Regulatory, Planning and Assessment.MBisson/GMansfield
Reference: SDC2021/0005.01
Phone: 02 4974 2000

4 June 2021

1A MCINTOSH DRIVE MAYFIELD WEST - RESOURCE RECOVERY FACILITY (SSD-7698-MOD 1)

Figure 4. Layout plan for proposed hand unload shed and apron area

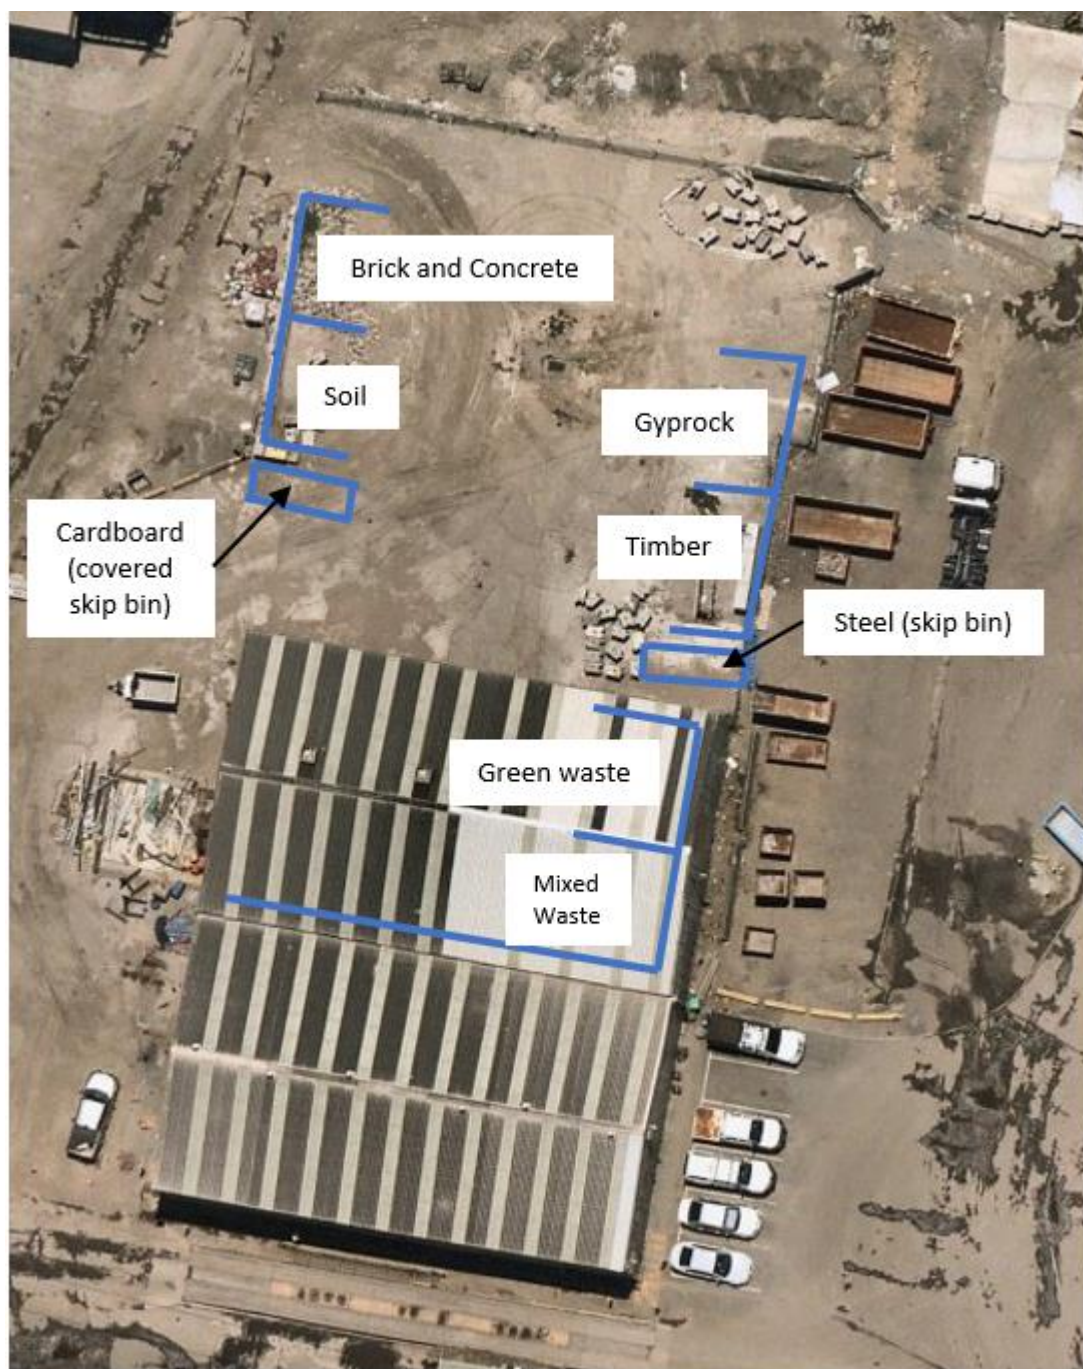
- An explanation as to why the proposed extension to the heavy material stockpile area is required given that the amended proposal does not involve any changes to the processing capacity or waste activities of the facility.
- Details of the activities to be carried out in the proposed Maintenance Shed and how they are associated with the waste recovery facility. It being noted that the submitted environmental impact assessment does not address the activities of the shed.
- The supporting report (Section 3.3 Pg. 9) states '*We now wish to modify the arbitrary boundary within the site and incorporate the proposed areas to stockpile recovered segregated waste materials, but not unsorted, co-mingled waste and the hand unload precinct.*' The proposed adjustment to the boundary as indicated in Figure 2 of the report appears to include land proposed to be used by all of the above activities.
